ELEVATIONS

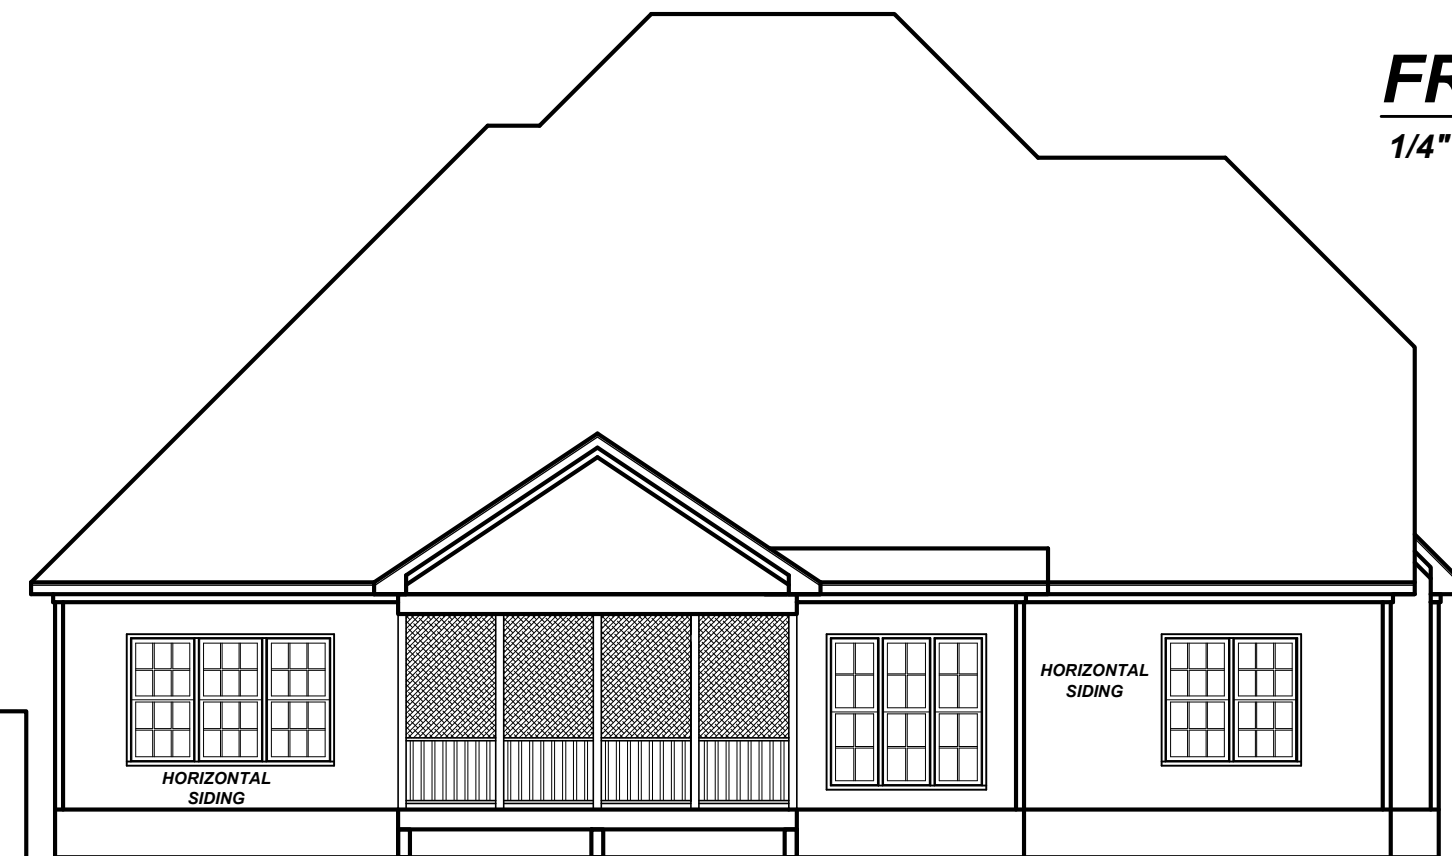
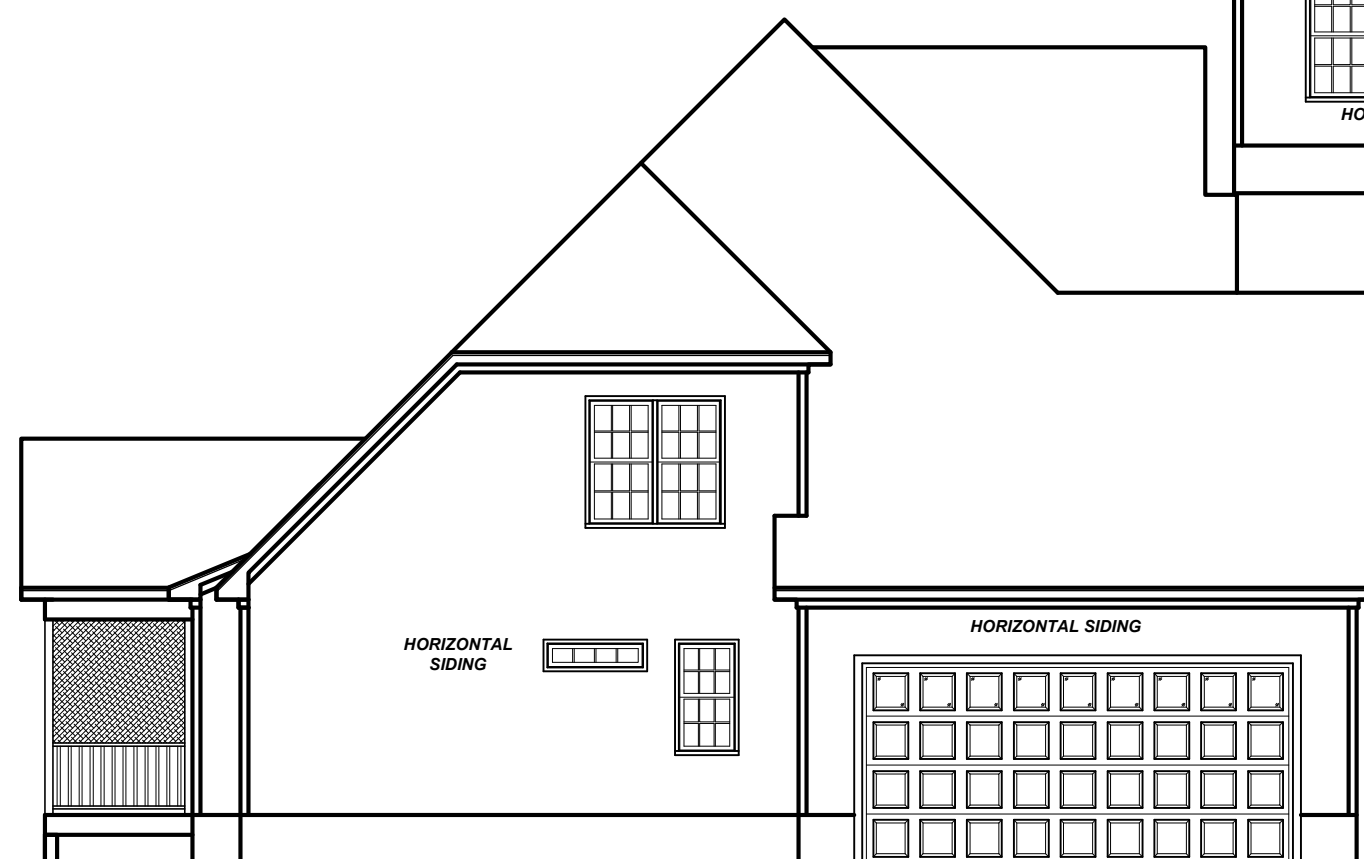
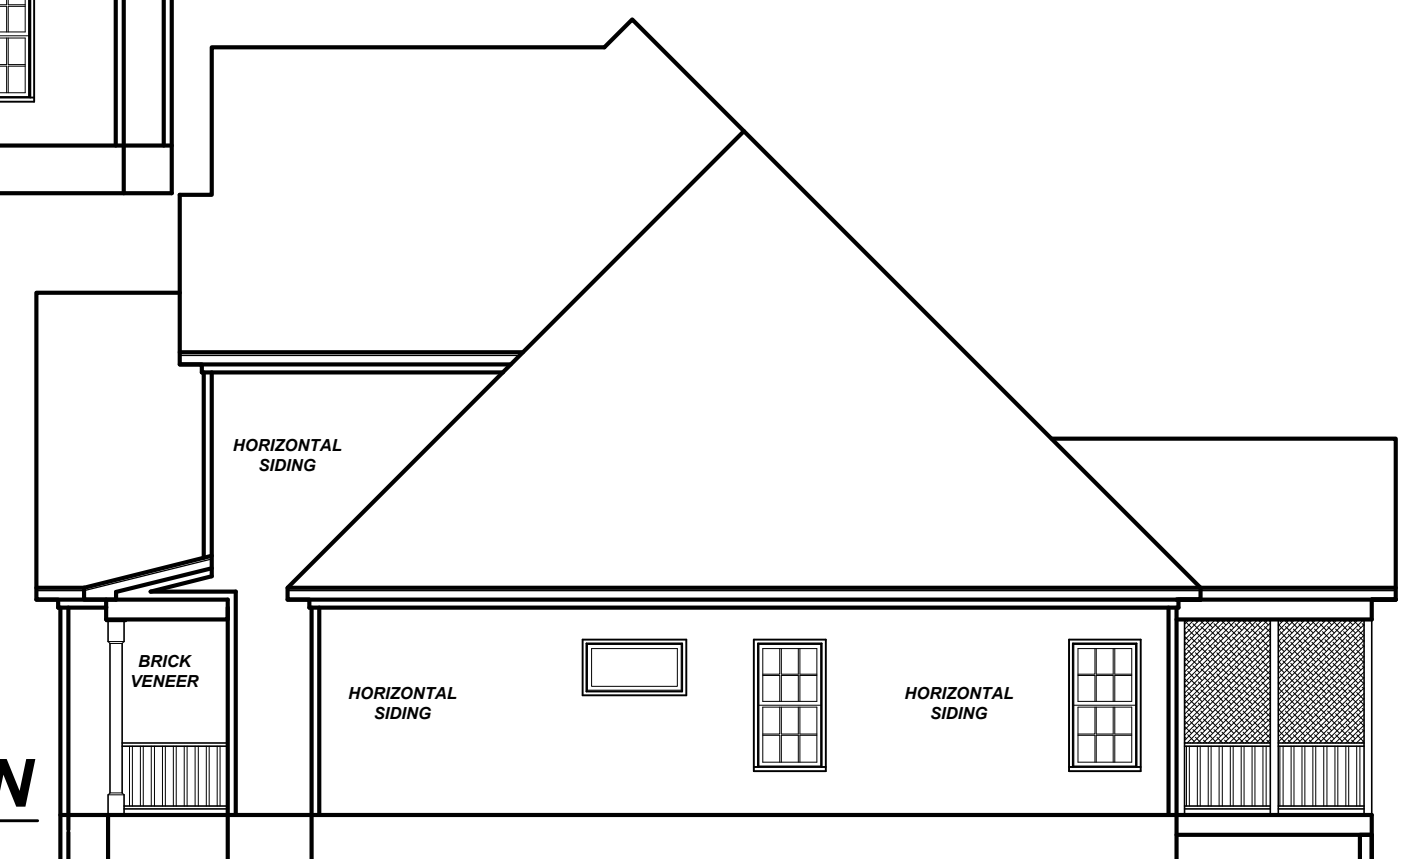
Field verify upstairs egress window sizes
